RE: La Luz del Oeste, Unit 4, Tracts M & N

Grading and Drainage Certification Engineer's Certification Date: 2/27/17

Hydrology File: F11D002A

Drawing file: F11D002A / F11D002A_PadCert_LotsK6-K11_Dis.pdf

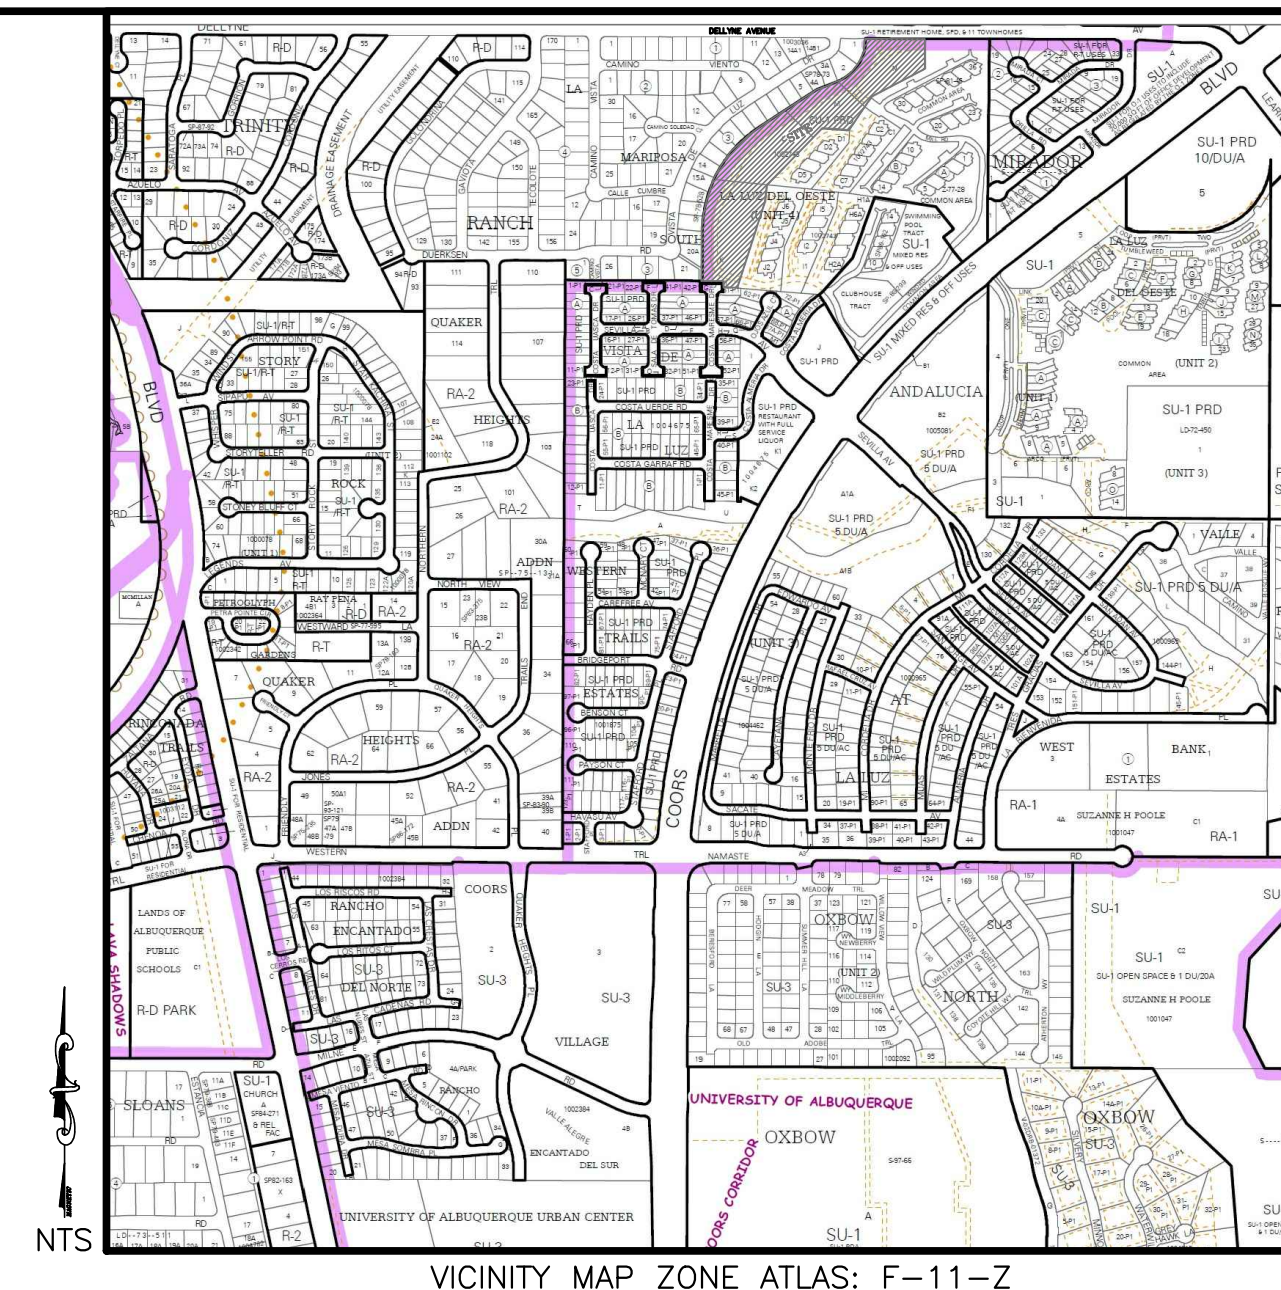
The slab is to be 0.33 feet thick. For Lot K-6, the FF was proposed at 14.85. 14.85-0.33=14.52. The pad is supposed to be at 14.5. The pad ended up at 14.

To match the FF elevation, would require a 10" slab, which will not happen.

It is common for the developer to leave a low spot on the lot for dirt that is generated when the home is constructed. Grades in this are not required or inspected. The four spots that are important for proper lot drainage are: 1. Top of curb/edge of pavement 2. Pad 3. Back corner 4. Other back corner.

The pad grade is low.

The pad certification was not approved because the lots are below the edge of pavement and it appears that water will pond next to the foundation on the uphill side of the lot.

It appears the pads are about 0.5 feet too low.

Are you going to pour a 4" or 6" thick slab for the foundation?

What is the problem with raising them up?

- Lots K-6 & K-7 have a pile of fresh concrete between them.
- Lots K-8, K-9, K-10 & K-11 pads are below the finish grade stake in the field and the FP call out on the plan are below the street elevation.

As I understand the process, the home builder (who is the subdivision developer) will match the finished floor elevation of the grading plan when constructing the foundation. As the home builder constructs the foundation for the home, excess dirt excavated from the footers will be used to fill around the foundation to build up the area so that ponding does not occur around the foundation. The builder is well aware that the finished floor elevation on the grading plan needs to be achieved in order for the drainage to work properly. So, once the home is built everything will drain properly. This process was followed for Lots K-4 and K-5. This situation is somewhat unique in that the home builder is the same as the subdivision developer.

Drawing file: FINAL / F11D002A_GP_Appr_Amend.pdf

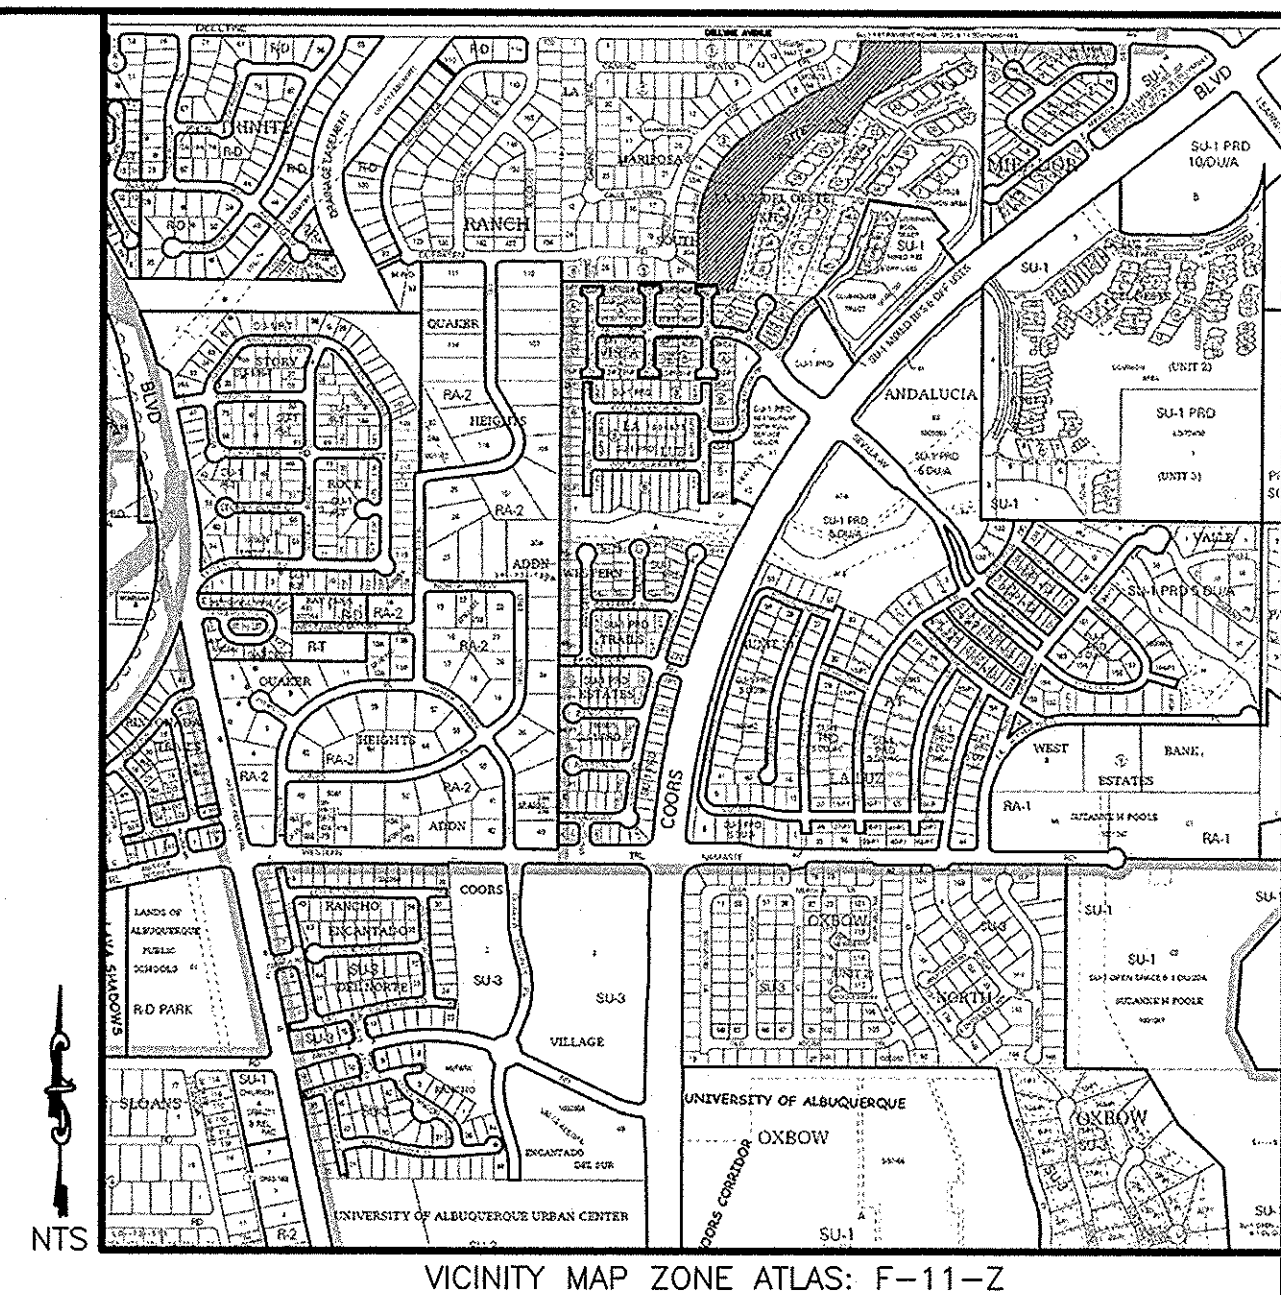
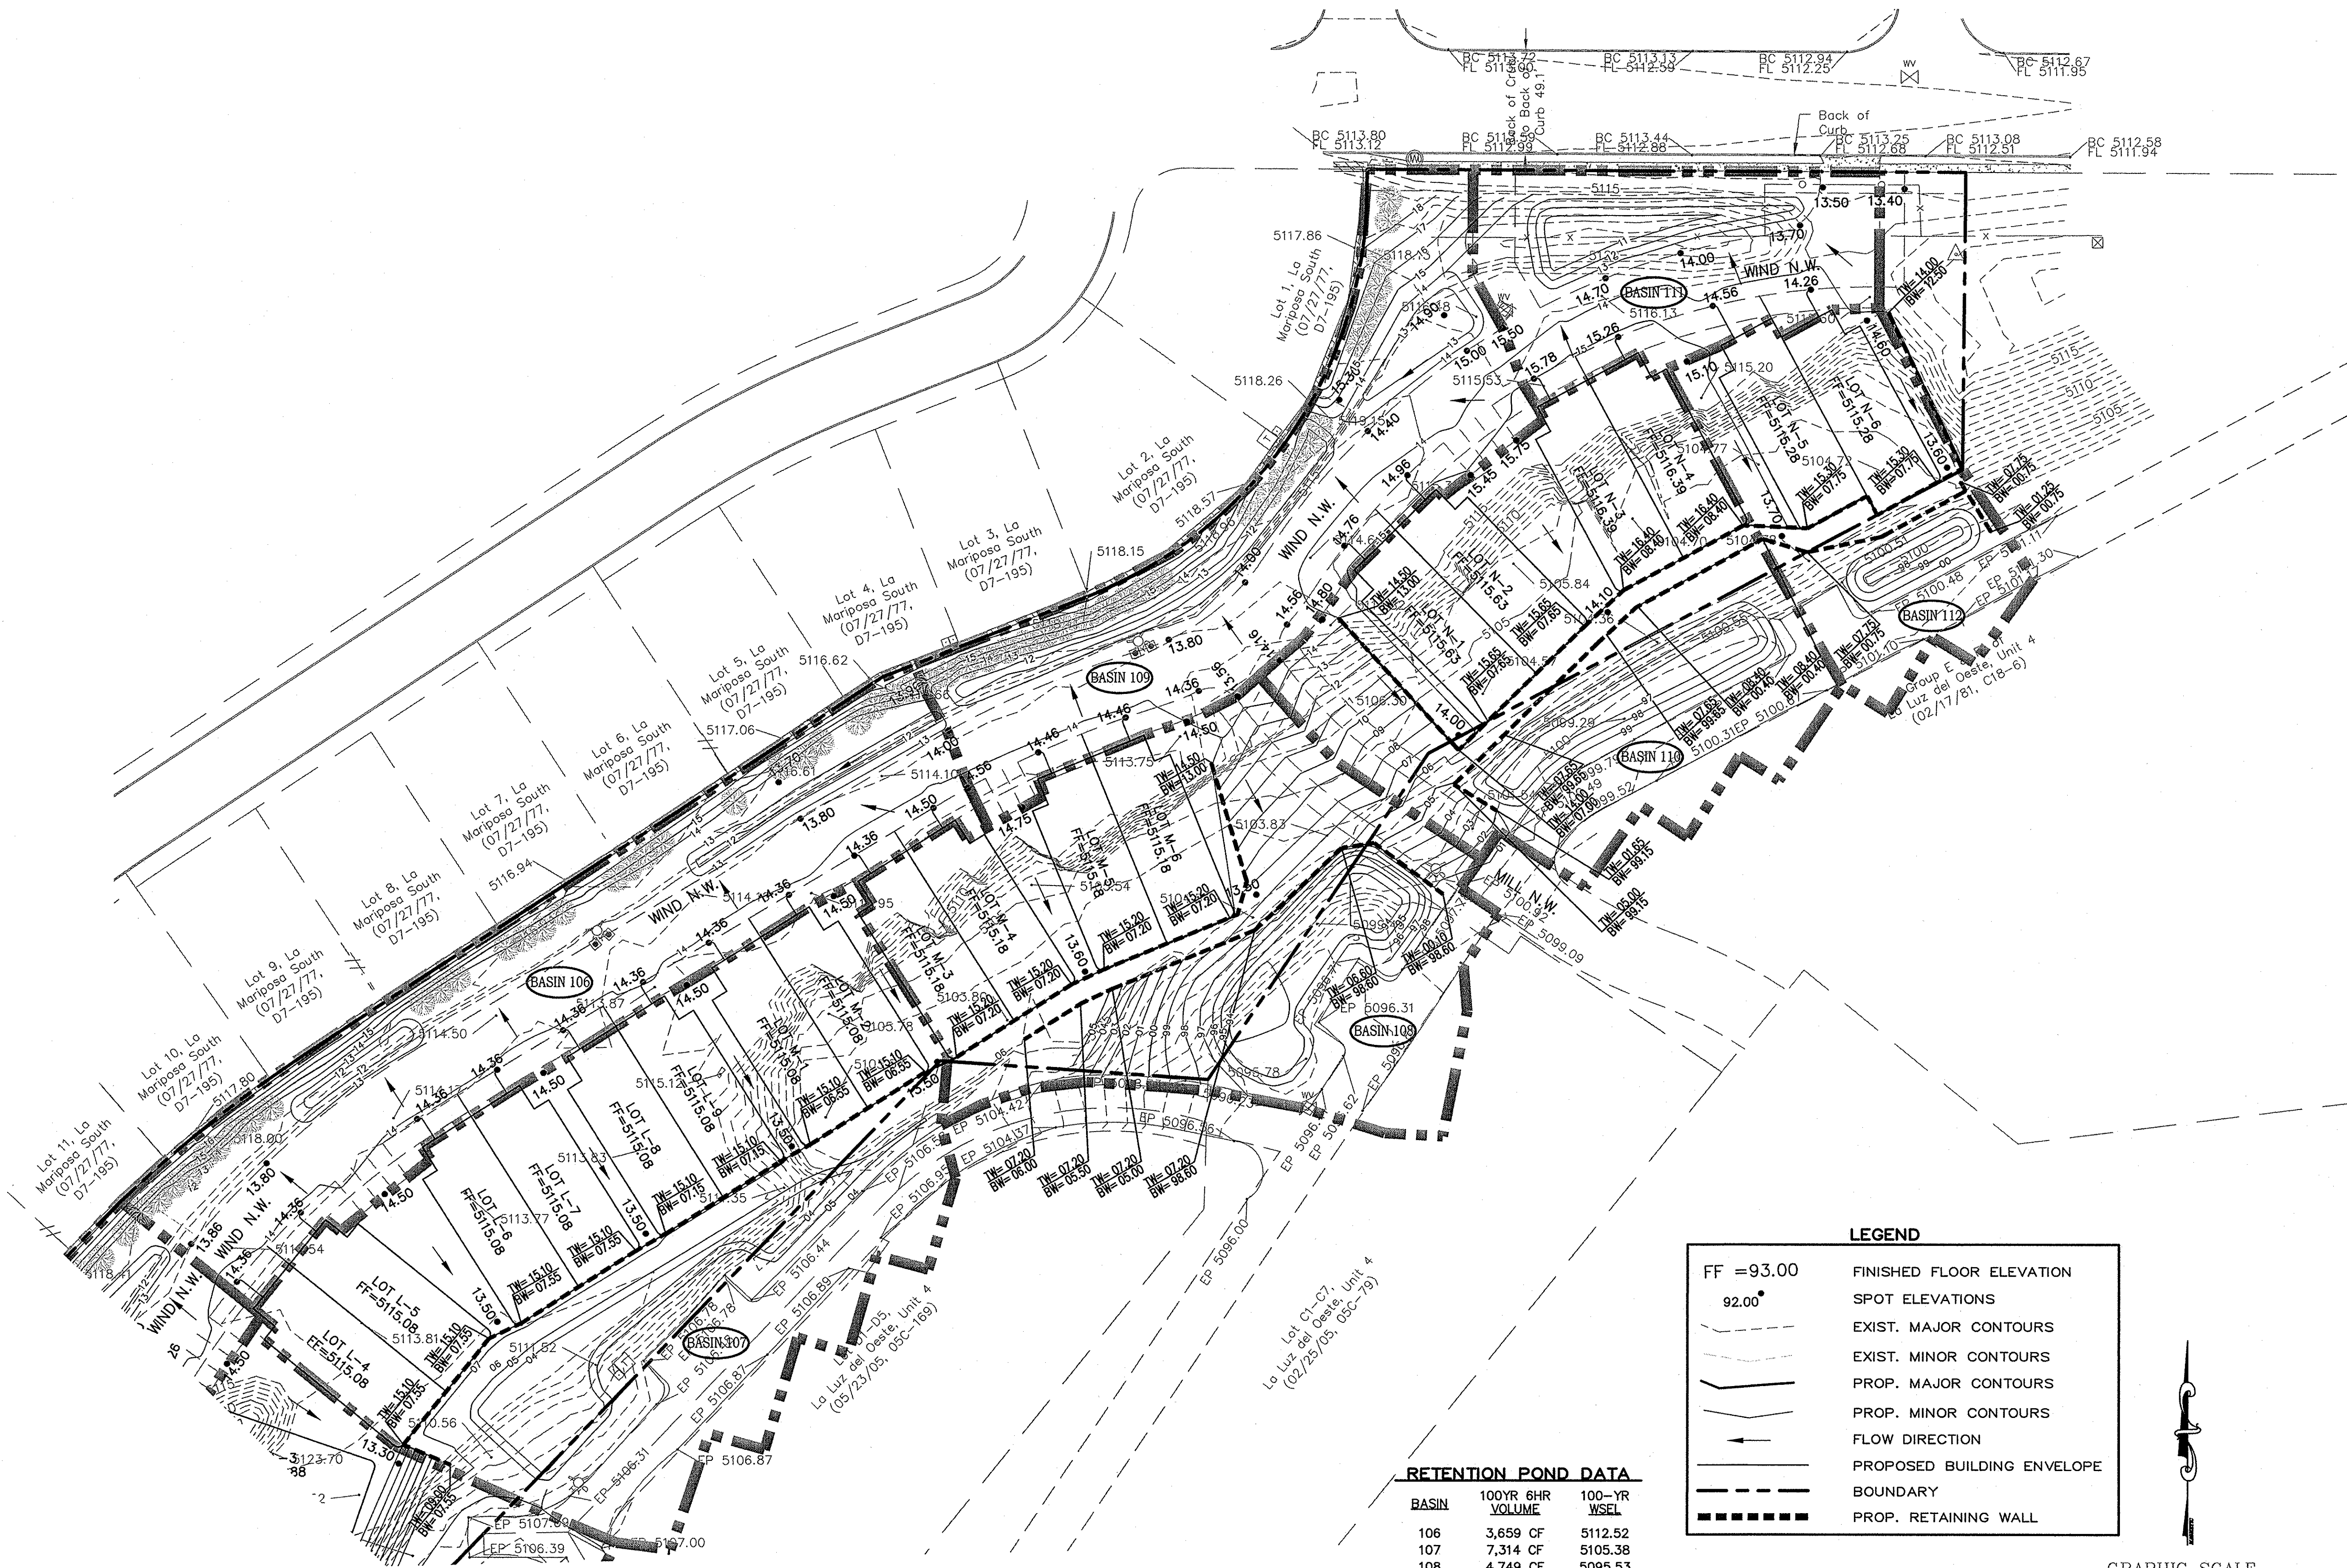
• Ponds in Basin 101 and 106 must maintain a percolation rate of 2.9 min/in. Pond volumes in these basins are considerably smaller than in the previously approved submittal. However, it is noted in the narrative that only the roadway drains to those ponds and a percolation rate of 2.9 min/in is used for the soils. The ponds only seem to be sufficient if the percolation rate is factored in. Therefore, provide percolation test data and note the percolation rate on the As-built Certification Plan.

- The Pad Elevations are higher than the previously approved submittal
- Distance between double retaining walls changed to 10' (not shown on section detail)
